**Dargues Reef Gold Project (MP 10_0054 Mod 3)
Response to Submissions**

I refer to your email dated 1 December 2015 regarding the response to submissions by Unity Mining Limited (the Proponent) to agency comments on the Environmental Assessment (EA) for a modification to the consent for the Dargues Reef Gold Project.

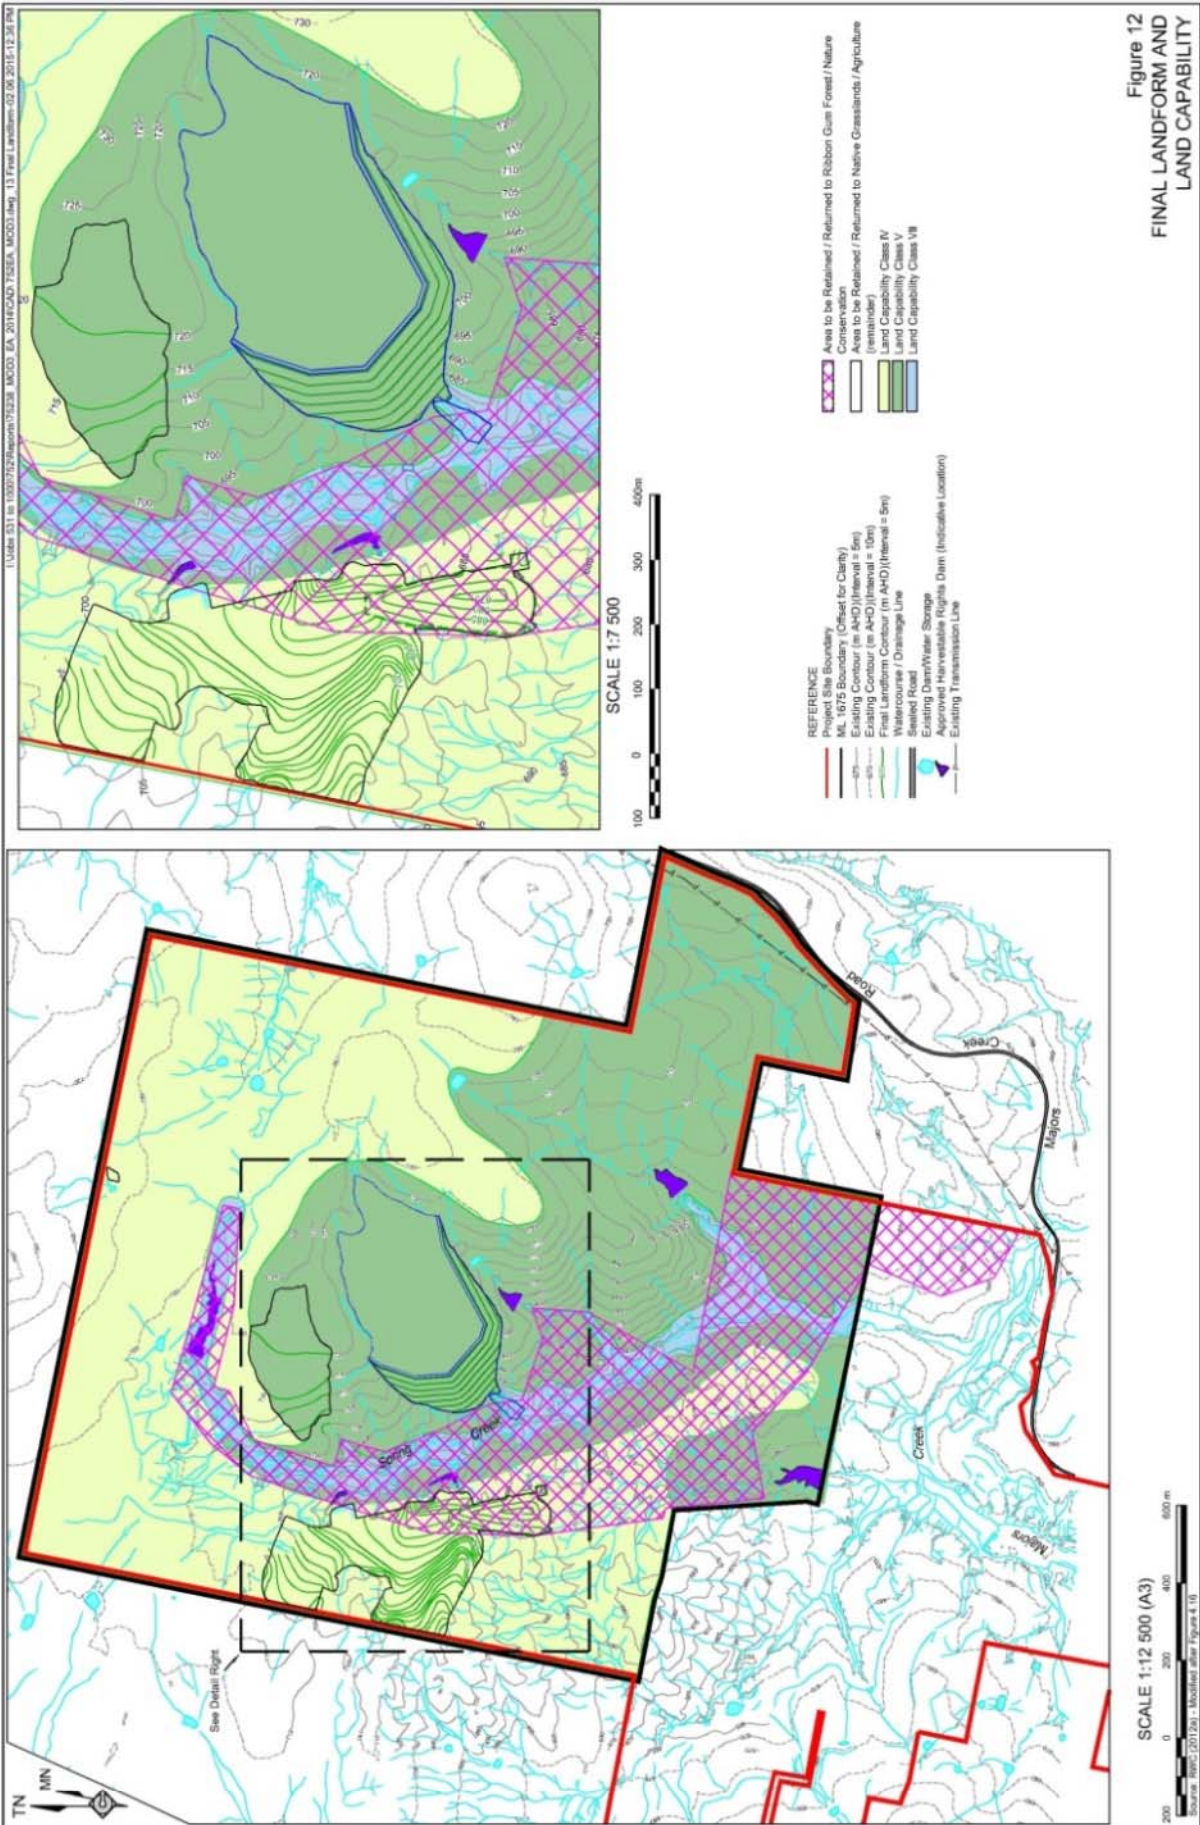
The Division has previously requested that the proponent consider utilising all available waste/fill material to backfill the approved initial box cut to the underground mine at completion of mining to ensure an optimum rehabilitation outcome (i.e. to avoid an unnecessary final void).

Given that the Eastern Waste Rock Emplacement (EWRE) is still proposed for construction and the bulk of this material was allocated for rehabilitation of the TSF, the Division would like to understand how the withdrawal of the enlarged TSF option will impact on the EWRE material mass balance and the likelihood of the box cut being completely backfilled and rehabilitated to original surface contours.
